Application for a non-material amendment following a grant of planning permission. Town and Country Planning Act 1990

Redevelopment of detached two bedroom bungalow

SDNP/23/00027/FUL

8. Non-Material Amendment(s) Sought

East, Rear Proposed Elevation
1:100

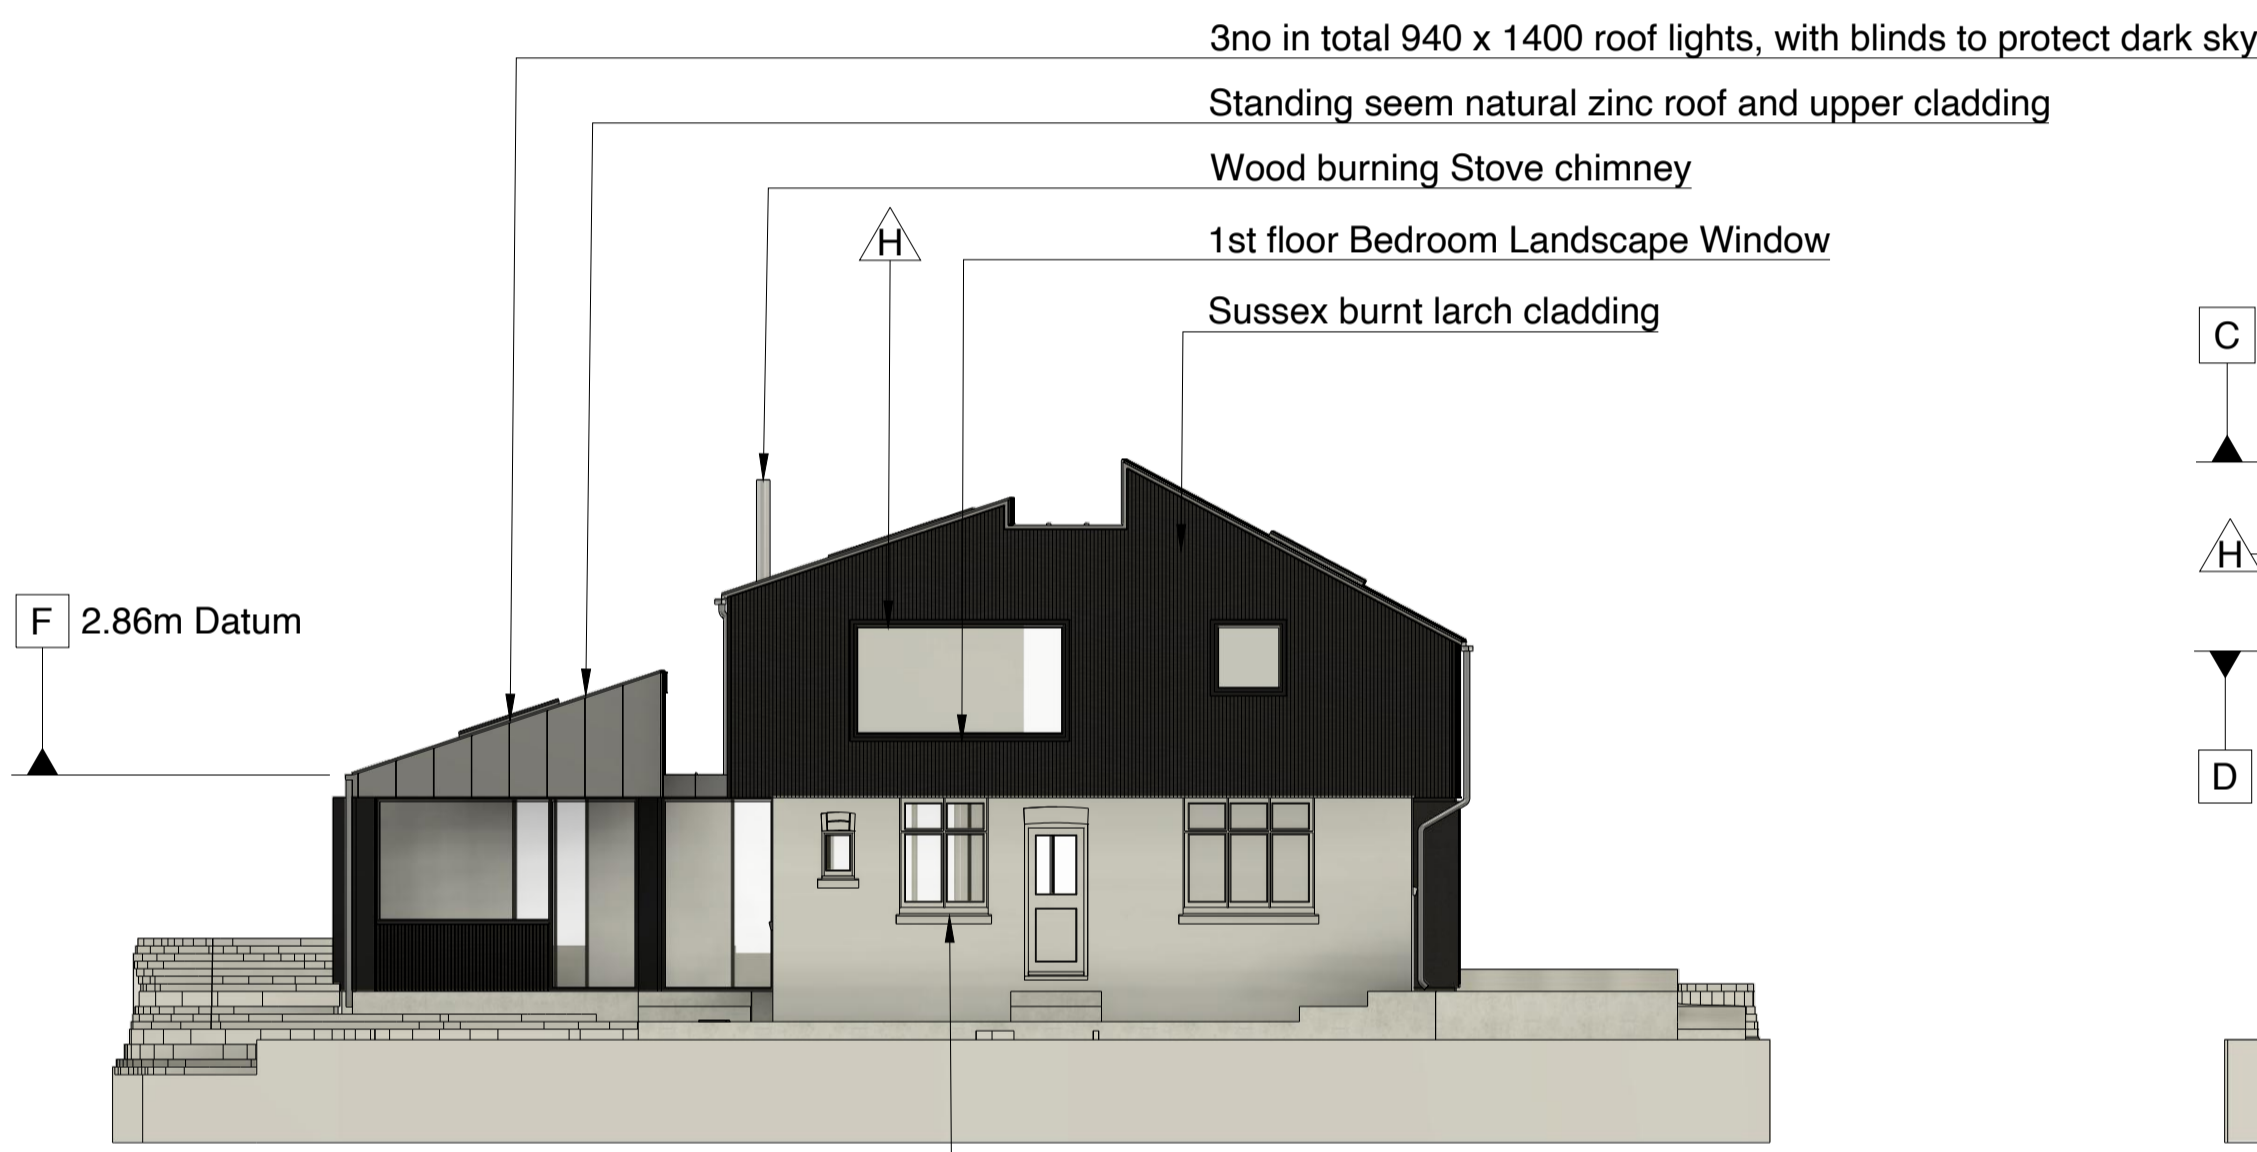
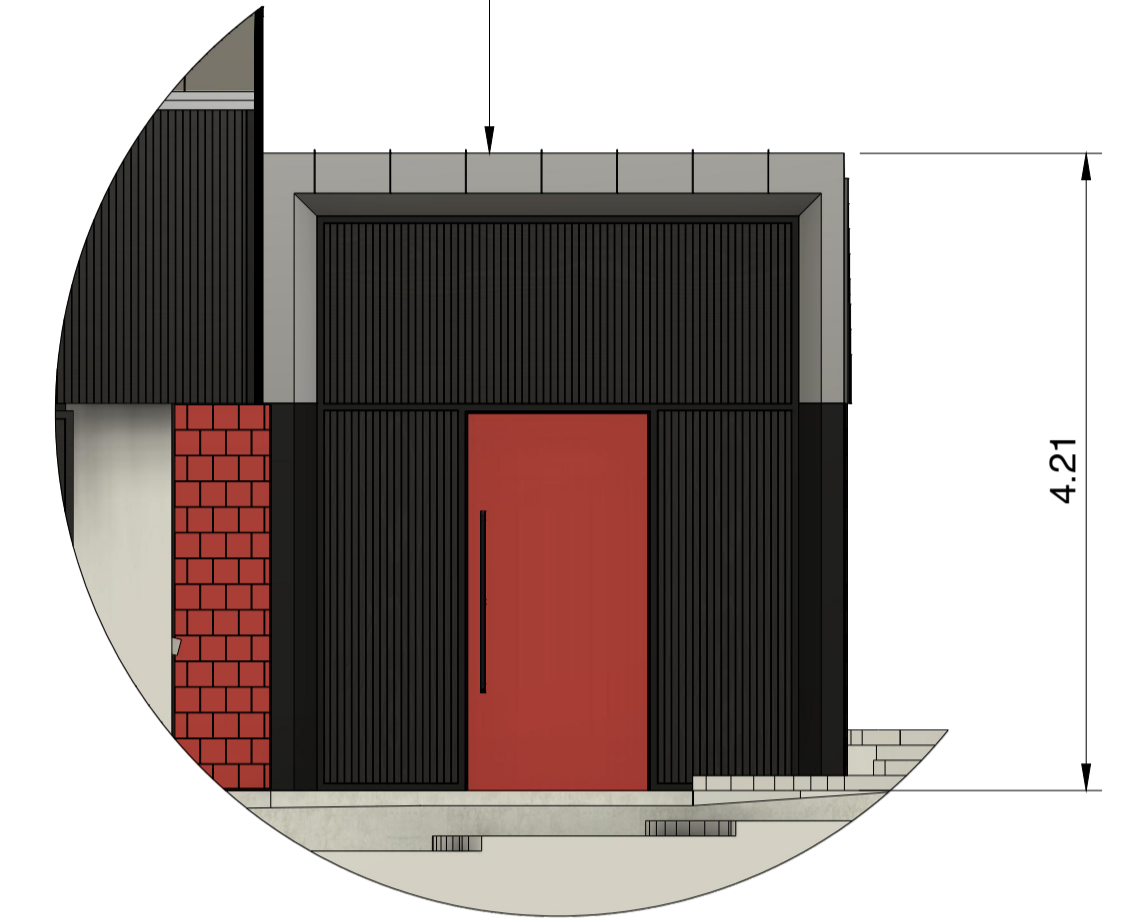
1. Reduce the size of the 3no Roof Skylights from 2x2m to 940mm Width x 1400mm (Cost Save). Retaining the internal Blinds to protect the South Downs Dark Sky.
2. Remove the provision of a Balcony to the rear elevation and replace with a single landscape Window 2800mm x 1500mm (Cost Save).
3. Split the two storey feature window to the front elevation at the first floor level (Cost Save).
4. Southern Kitchen Window to Extension moved 300mm (Design Correction).
